From:**Sent:** 16 June 2020 11:42**To:** Nick Hirst <Nick.Hirst@kirklees.gov.uk>**Subject:** Re: DOC 2020/90441 at Pennine Service Station, Bradley Road, Bradley, Huddersfield, HD2 1QD

Please see the attached comments from EV Health, requesting more details to discharge condition 6.

Application 2020/90441 at Pennine Service Station, Bradley Road, Bradley, Huddersfield, HD2 1QD for Discharge conditons 3, 5, 6, 7, 18 on previous permission 2019/92233 for erection of petrol filling station, including new shop building, canopy, jet-wash and below ground storage tanks has been delegated to you.

Site 1

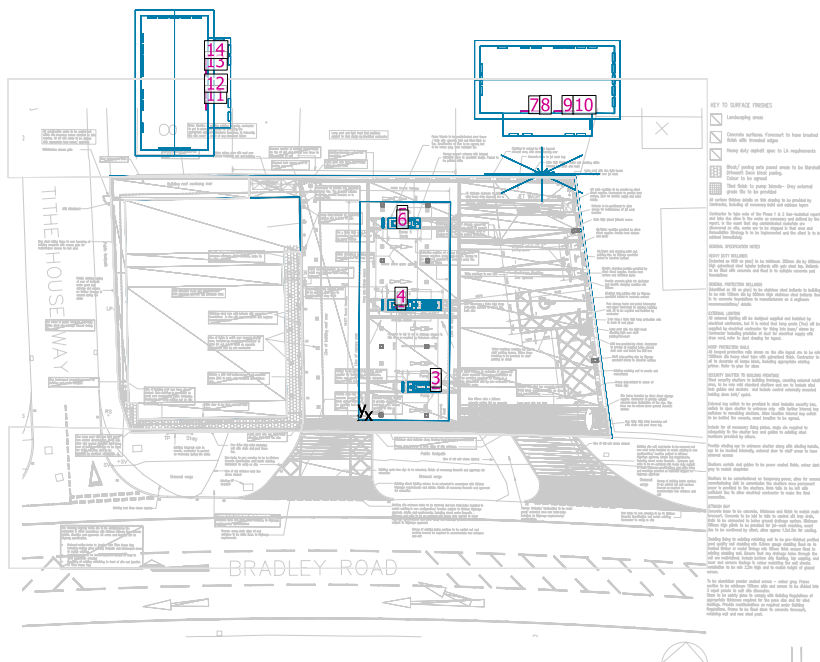
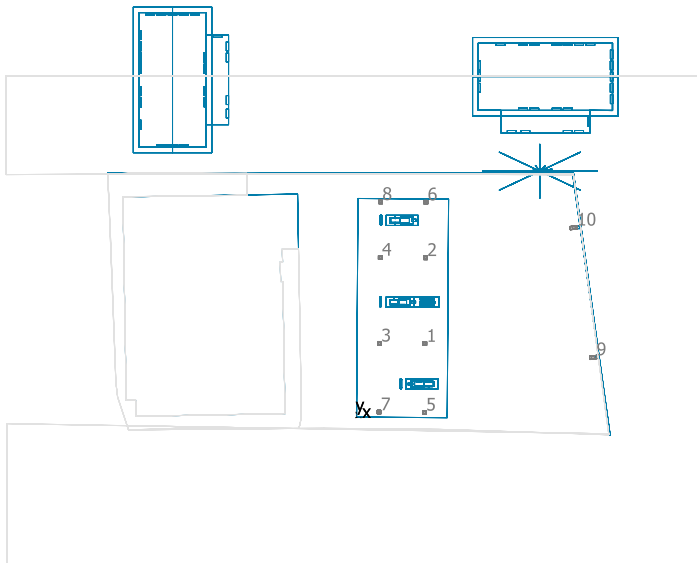
3. Vertical illuminance levels that will be caused at any nearby windows to demonstrate that it's not excessive.

Reply: Vertical lighting values now shown on houses at rear based on estimated positions of bedroom windows as shown - note that the rear most lights in the canopy have optics that tilt the light away from the houses. The same lights are already used on the front row to control the light spill to keep away from the road

Workplane (Site) / Perpendicular illuminance (adaptive)**Workplane (Site): Perpendicular illuminance (adaptive) (Surface)****Light scene: Light scene 1**

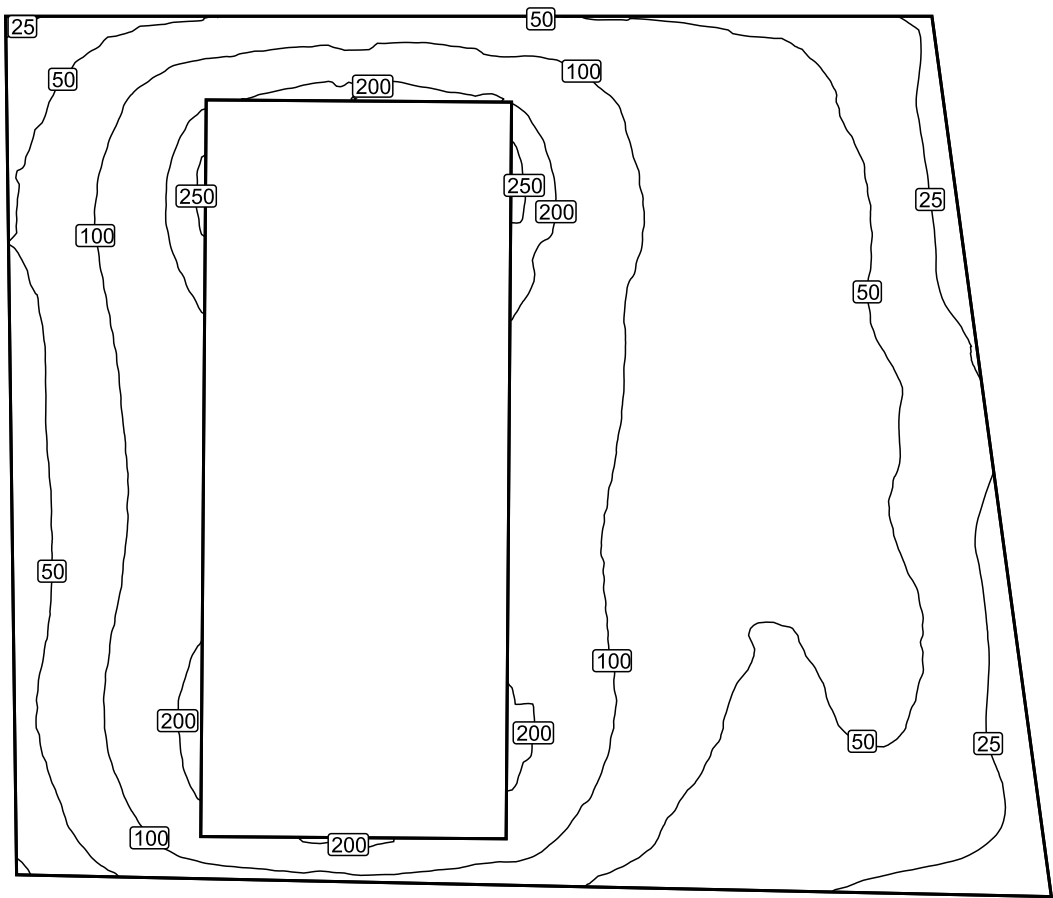
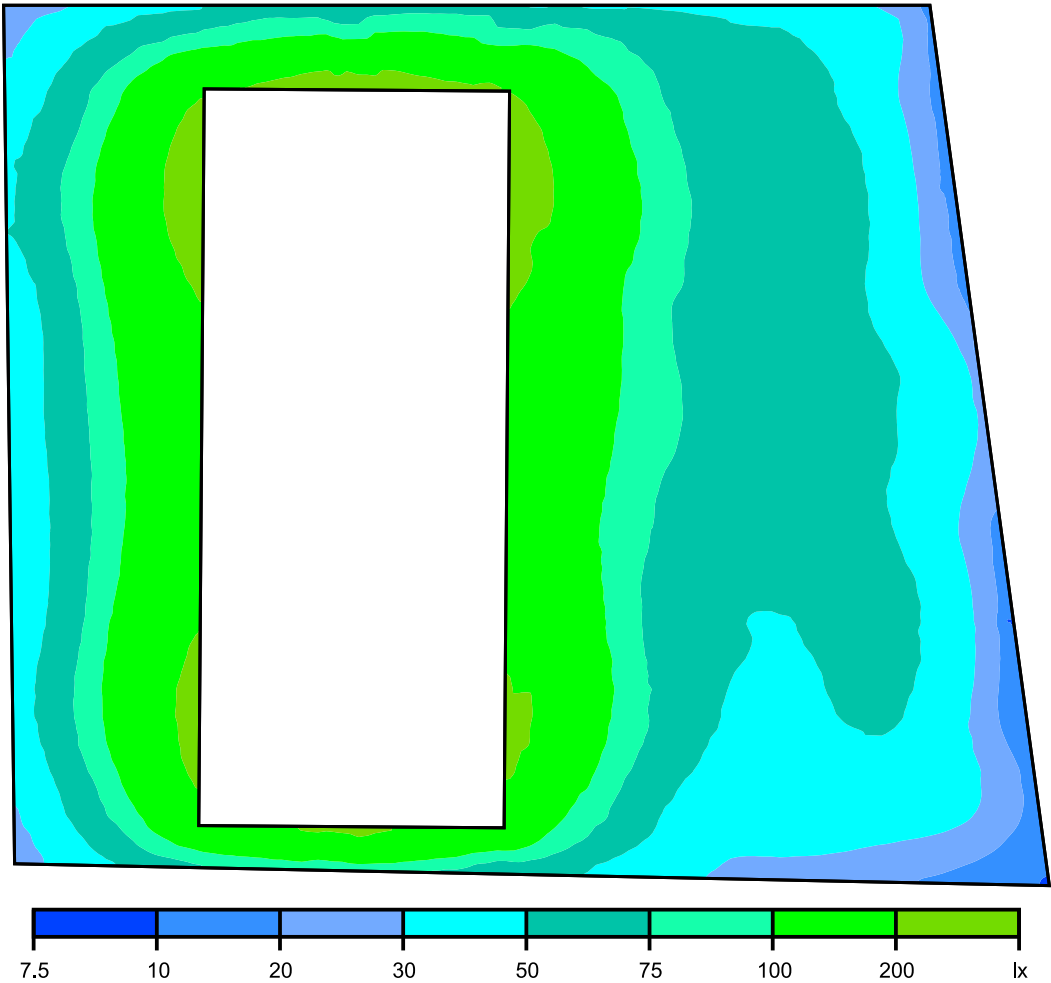
2. I also require the horizontal illuminance levels for the site (with some reference to guidance to demonstrate that they are appropriate and not excessive)

Reply: Horizontal lighting levels of around 300 lux are generally required to meet aspects of Shell spec for example, more for some and less for others, so a good benchmark

I would also note that the lighting levels on the site have been lowered to a minimum that will retain reasonably close compliance for minimum maintained levels in BS EN12464-2 without a change of equipment or layout.
